**SSD-79316759 – 45-53 Macleay Street, Potts Point**

Thank you for the opportunity to provide feedback on the Concept Proposal for 45-53 Macleay Street, Potts Point SSD-79316759. I wish to object to several elements of the concept plan.

Envelope Plan - Level 3

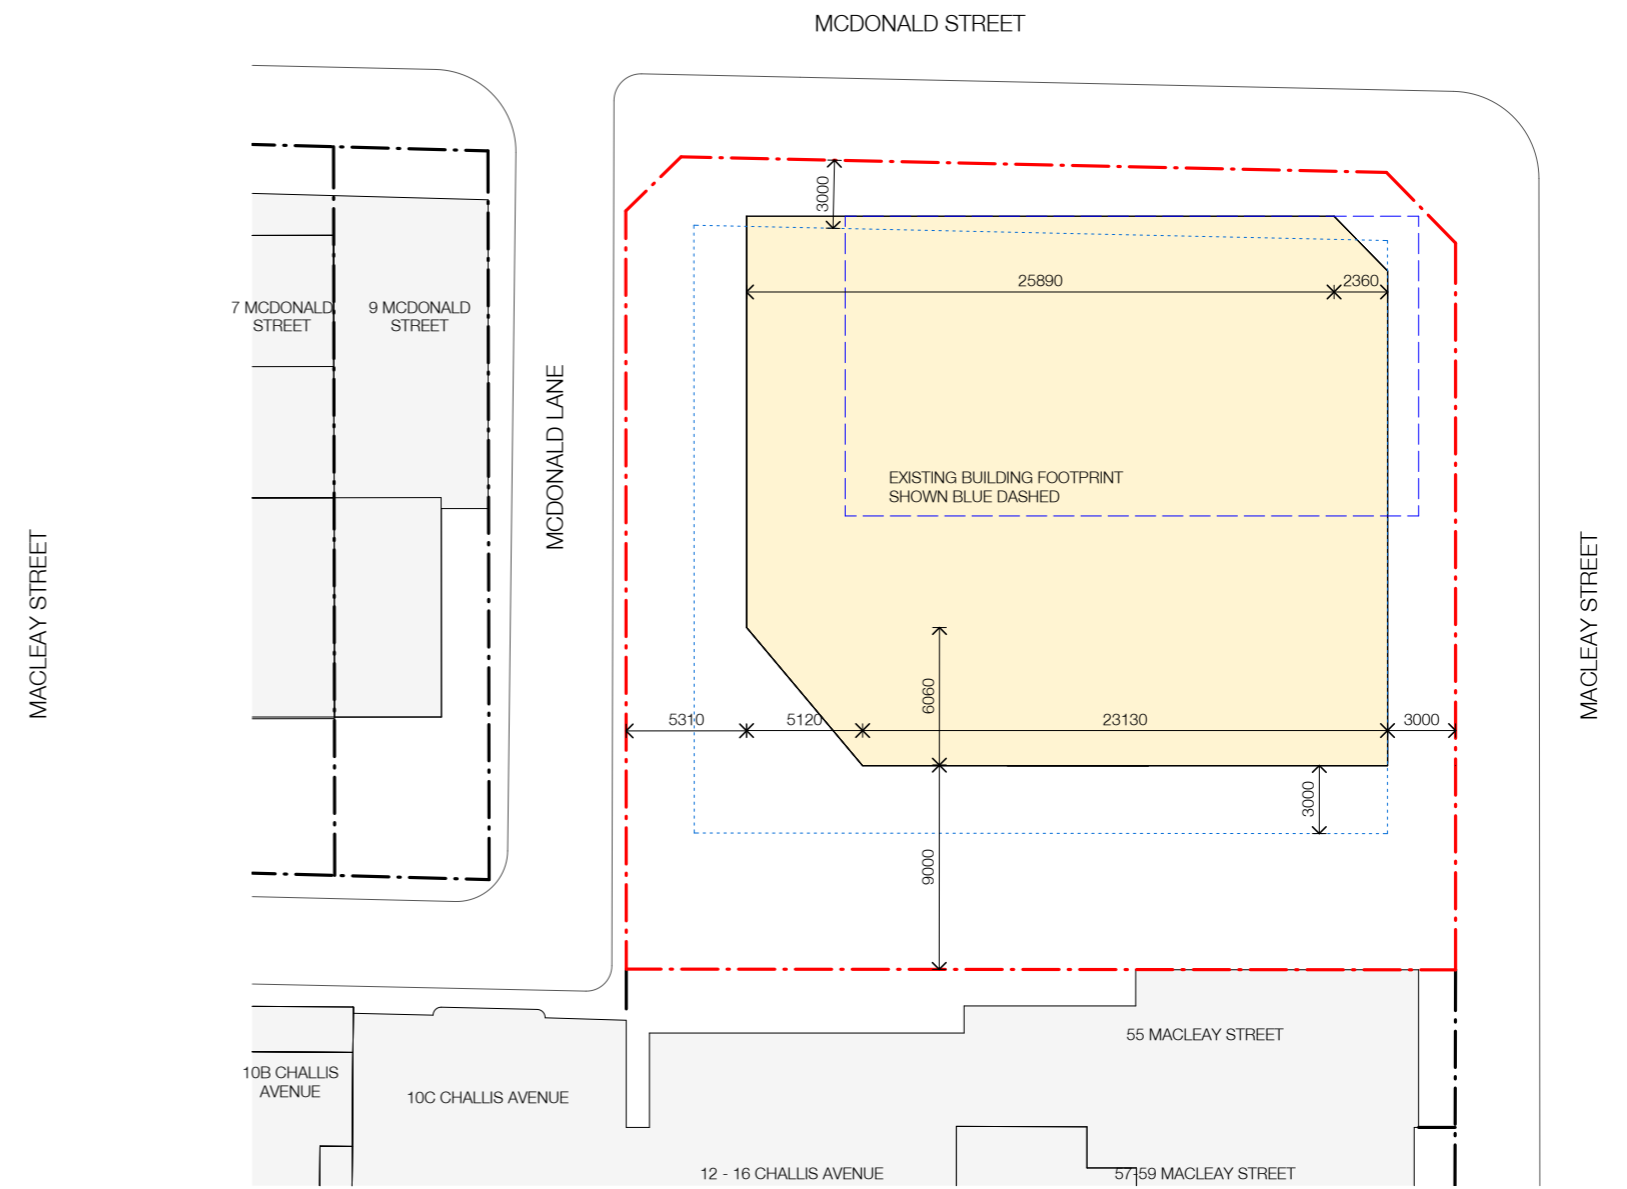
The proximity of the concept communal facilities, including a swimming pool, will adversely impact the quiet enjoyment and privacy of west-facing Yellow House apartments. The configuration of the surrounding buildings (as mentioned above) combined with the bulk and proximity of the concept building will lead to a 'echo chamber' effect.

The proposed open plan Level 3 communal facilities and outdoor gym will exacerbate this. Indeed, I do not understand the need for these facilities at this level. Is it motivated by achieved an additional level in valuable height if this open area is not calculated in floor space?

CoS Solar Access Data Tables

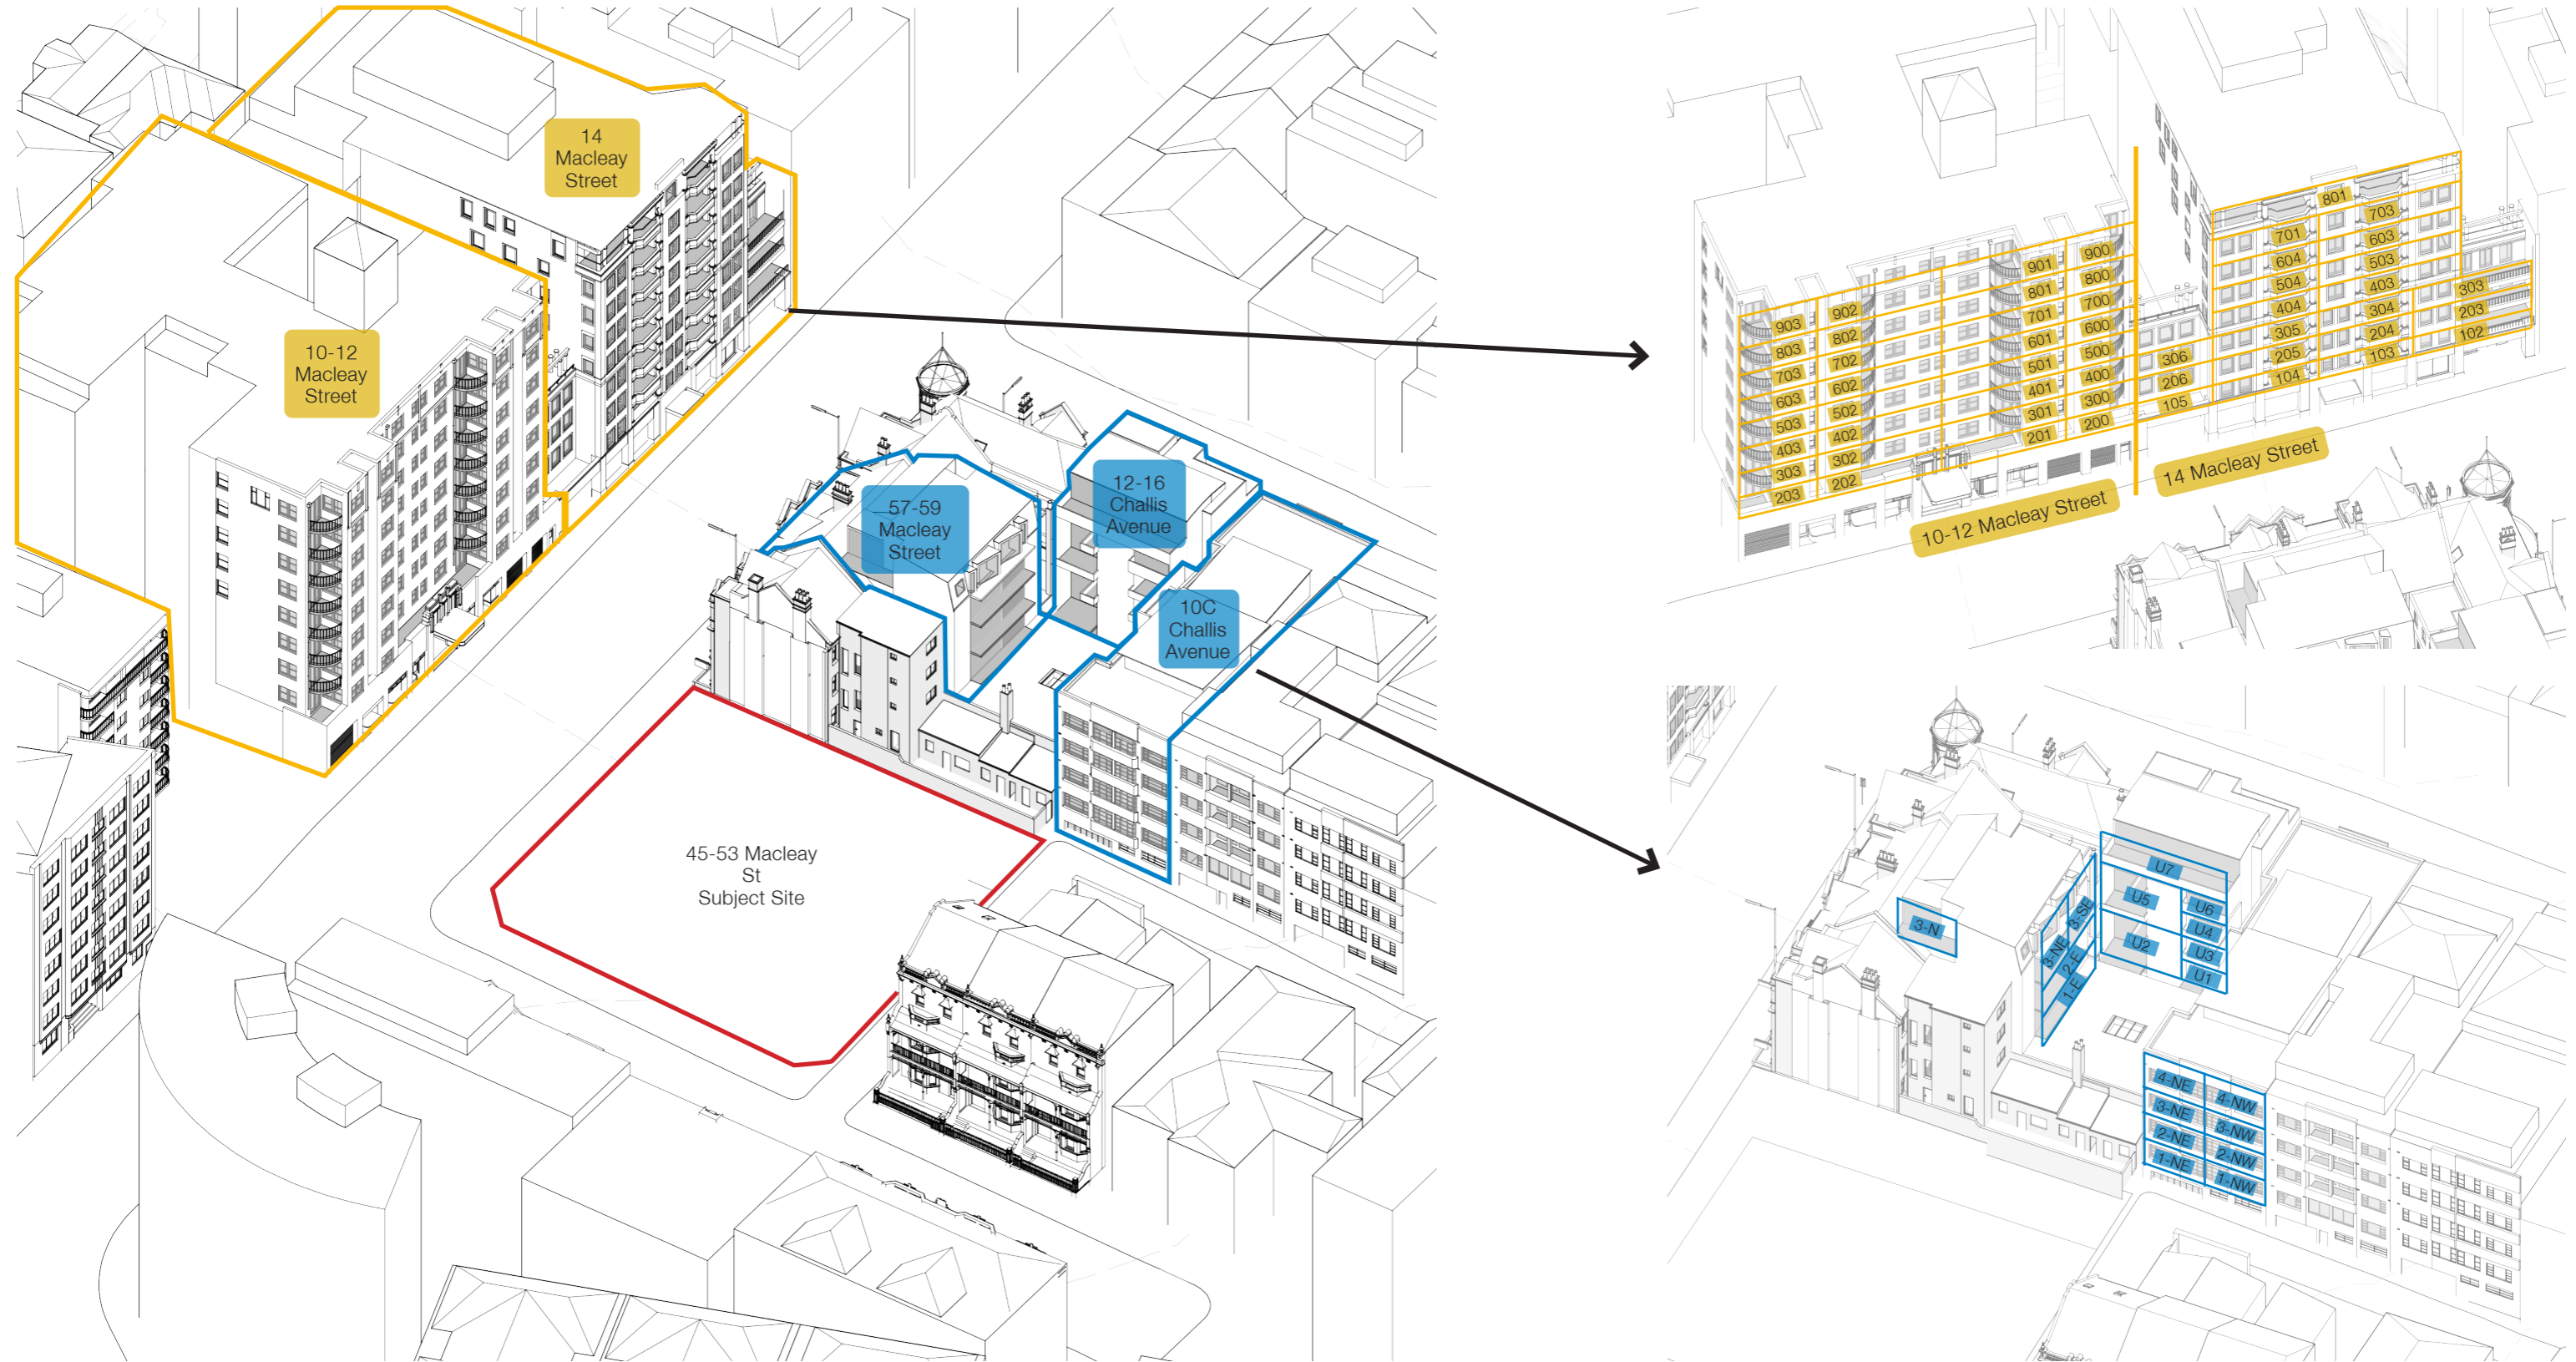
The proponent's own data shows significant reduction in sunlight for all Yellow House apartments, ranging from 10% to 50%. (Extracted from *CoS Solar Access Data Tables*) but is not considered significant in the proponent's reports. Add to this the flaw mentioned above and the impact is underestimated.

I note that the data extracted from the tables shows that even the 'Envelope Without Bonus Height' has this adverse impact – indicating that the footprint size is the major contributor to the reduction in sunlight to the Yellow House apartments.
